Consultation Response from: KC Environmental Health (Pollution & Noise Control)
2023/91405 - Part of former St Luke's Hospital site, Blackmoorfoot Road, Crosland Moor, Huddersfield, HD4 5RA
Erection of foodstore (class E) with associated access, parking, servicing area and landscaping
**Date Responded:
9th February 2024**
**Responding Officer:
RM, MN, SR & NH**
**Responding Ref:
WK/202401040**

**Appendix 2
Proposed Layout Plan and Boundary Treatment**

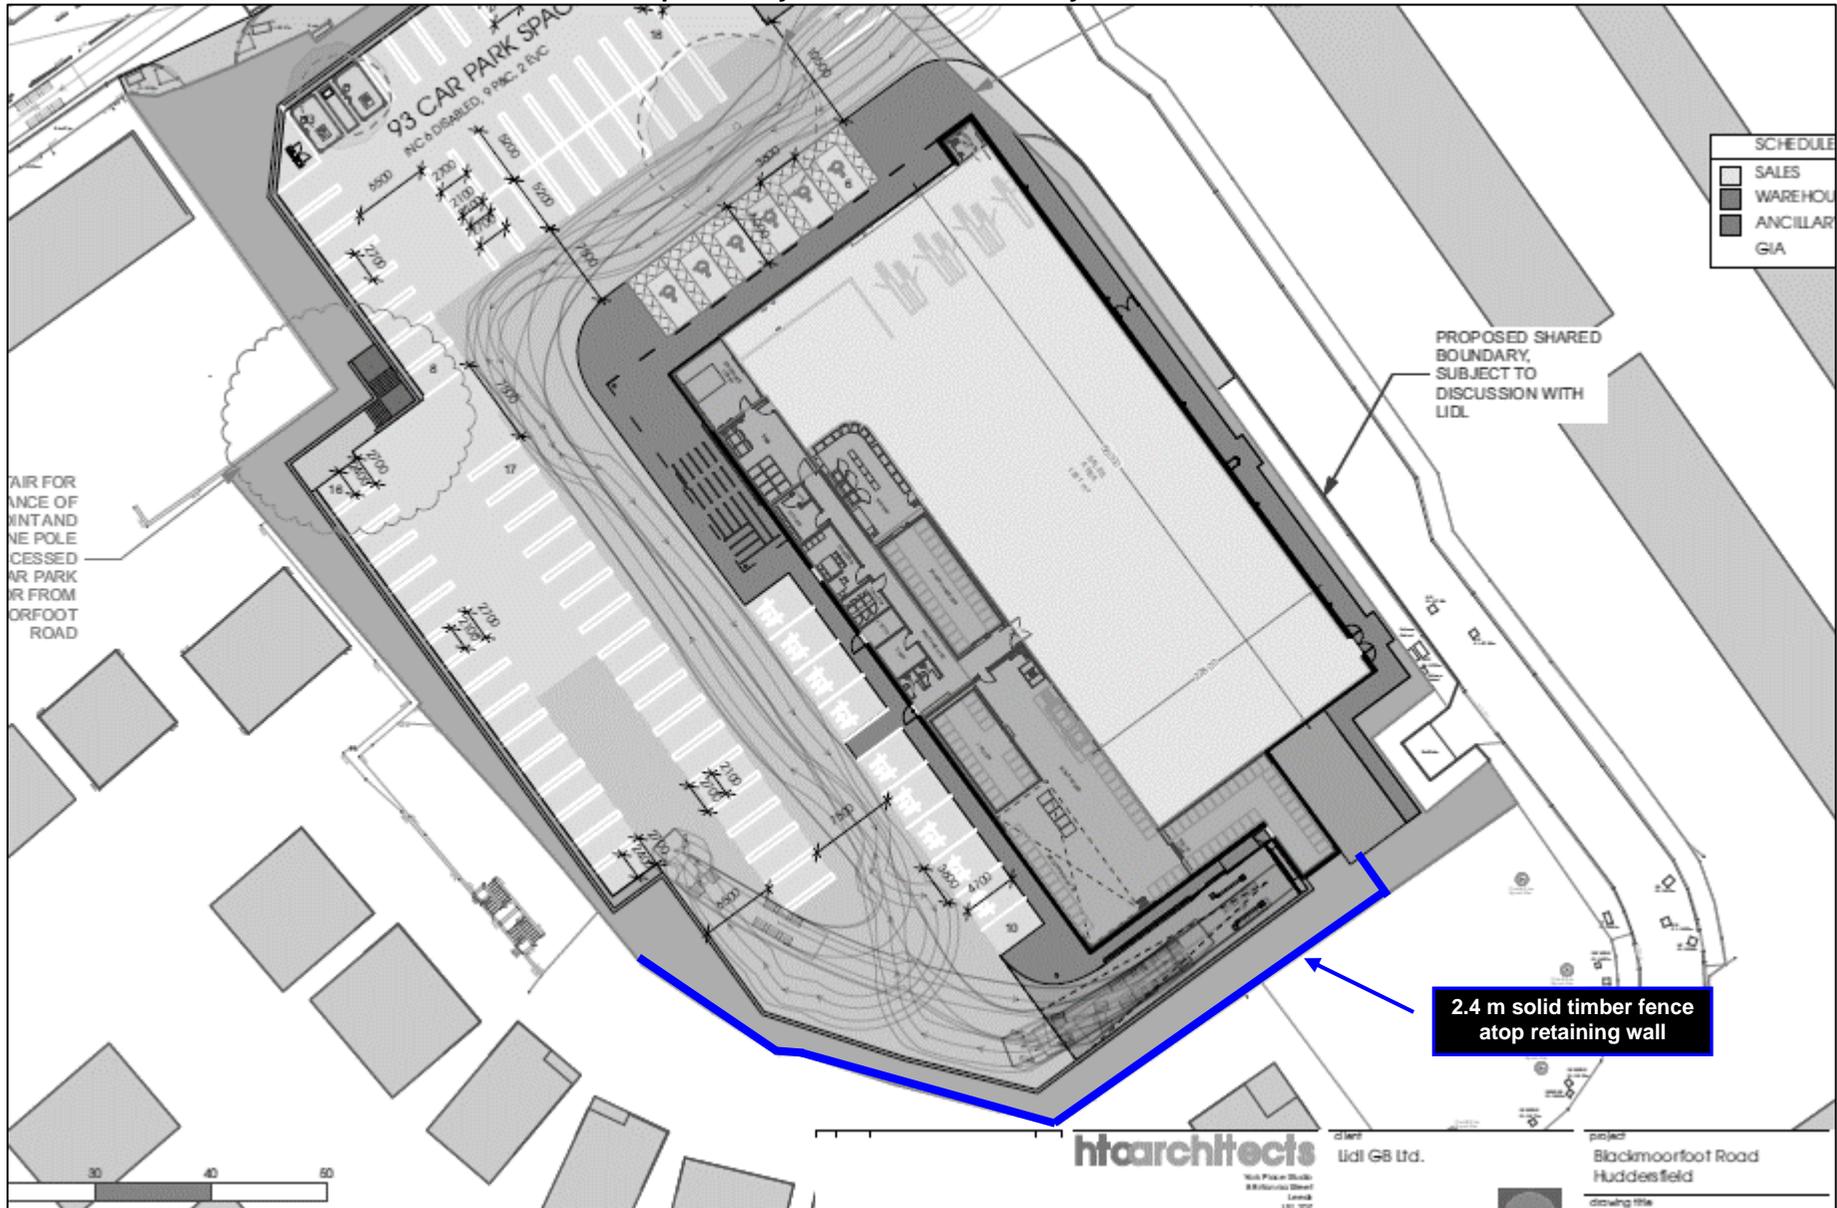
The noise associated with the store deliveries is based upon historic library data from similar stores and this is accepted. Para 2.03 identifies the nearest noise sensitive receptors (NSRs 1, 2 & 3) and para 5.09 states in order to screen NSR1 from the effects of the loading bay, a

2.4m high solid timber fence must be installed along the south-eastern and southern sites boundaries as shown in Appendix 2 stating the base of the fence should be on top of the proposed retaining wall. For all other NSRs, table 5.2 shows the predicted levels to show a low impact based upon distance attenuation. A BS4142 assessment has been conducted and after applying penalties for impulsivity (+6db at NSR1 and +3dB at NSRs 2 & 3), the results indicate a low impact and this is accepted. A condition is recommended for the submission of a Delivery Management Plan to address any operational noise not covered in the assessment e.g. reversing beepers, refrigeration units, vehicle engines left running etc.

Whilst the mitigation measures proposed for both the fixed mechanical plant and the delivery noise are accepted, no consideration has been given to the noise from the use of the car park. We have concerns about the impact of the use of the car park upon the amenity of the neighbouring properties and recommend a condition for a further/addendum Noise Impact Assessment to be submitted.

Before construction work commences, a further/addendum noise assessment report by a suitably competent person shall be submitted to and approved in writing by the Local Planning Authority. The report shall include:

- an assessment of all noise emissions from the car parking area of the proposed development

- details of existing background and predicted future noise levels at the boundary of the nearest noise sensitive premises
- a written scheme of how the occupants of the above-mentioned noise sensitive premises will be protected from noise from the proposed development including details of all necessary noise attenuation
